Request for Additional Information

Section 4.55(2) Modification – Trading Hours and Patron Capacity at the Overseas Passenger Terminal (Tenancy 5) at The Rocks, Circular Quay (SSD 7683 MOD 2)

**LEVEL 2**

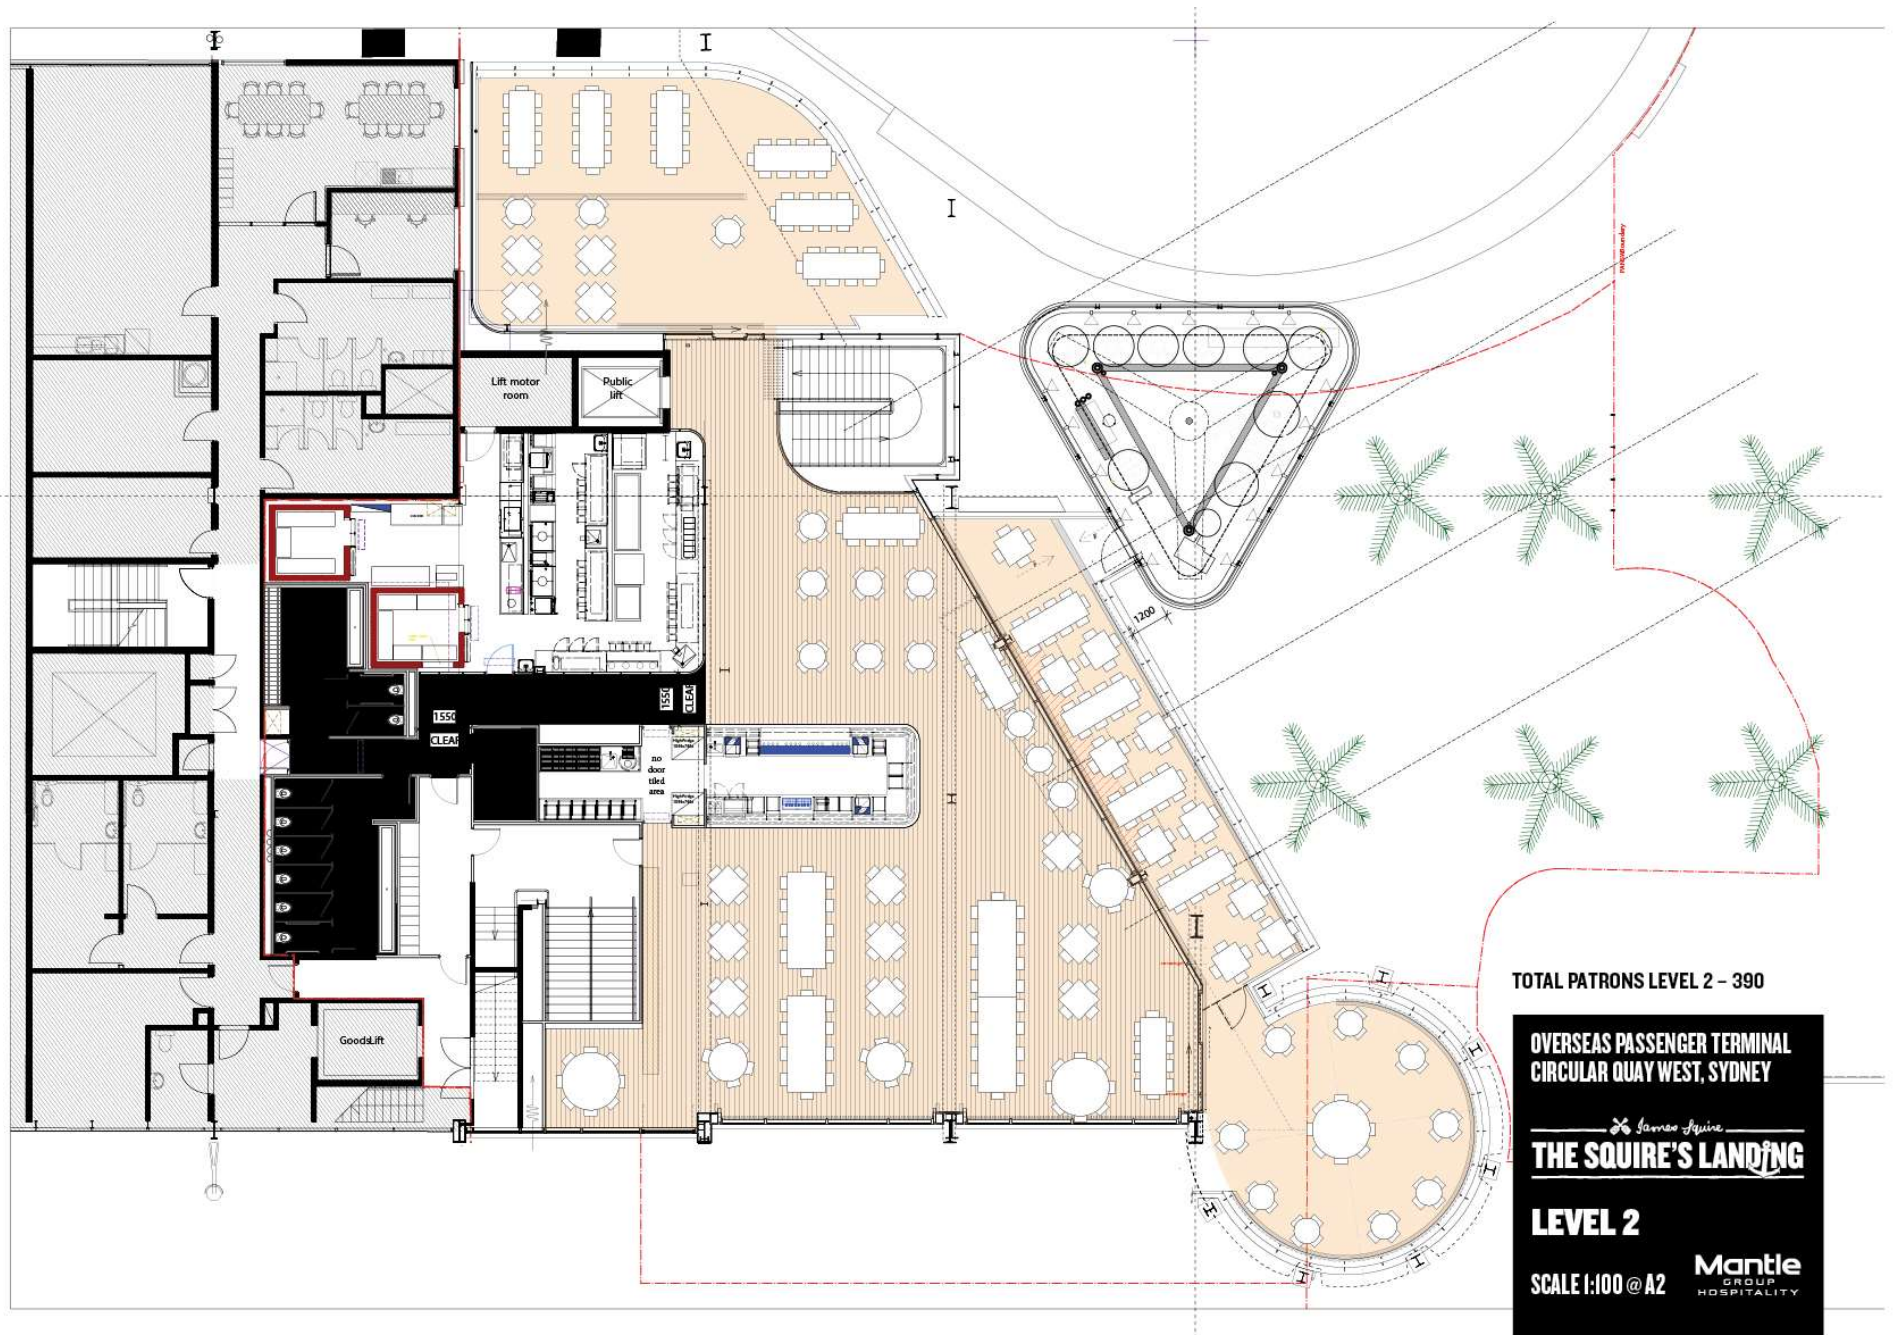
As you are aware, the modification application proposes to increase the maximum patron capacity from 800 to 1,000 patrons in the premises at any one time. The Department has requested that the venue floor plan (provided in the submitted Plan of Management, dated April 2019) demonstrate that a comfortable dining position for the proposed number of patrons can be achieved in order to comply with Condition F4(iii) of the consent for SSD 7683.

I can confirm that the premises will provide a total of 1,054 seats with access to a table/bench space including 664 seats on the ground floor and 390 seats on Level 1. This is confirmed on the marked-up venue floor plans provided at **Appendix A** (ground floor) and **Appendix B** (Level 1).
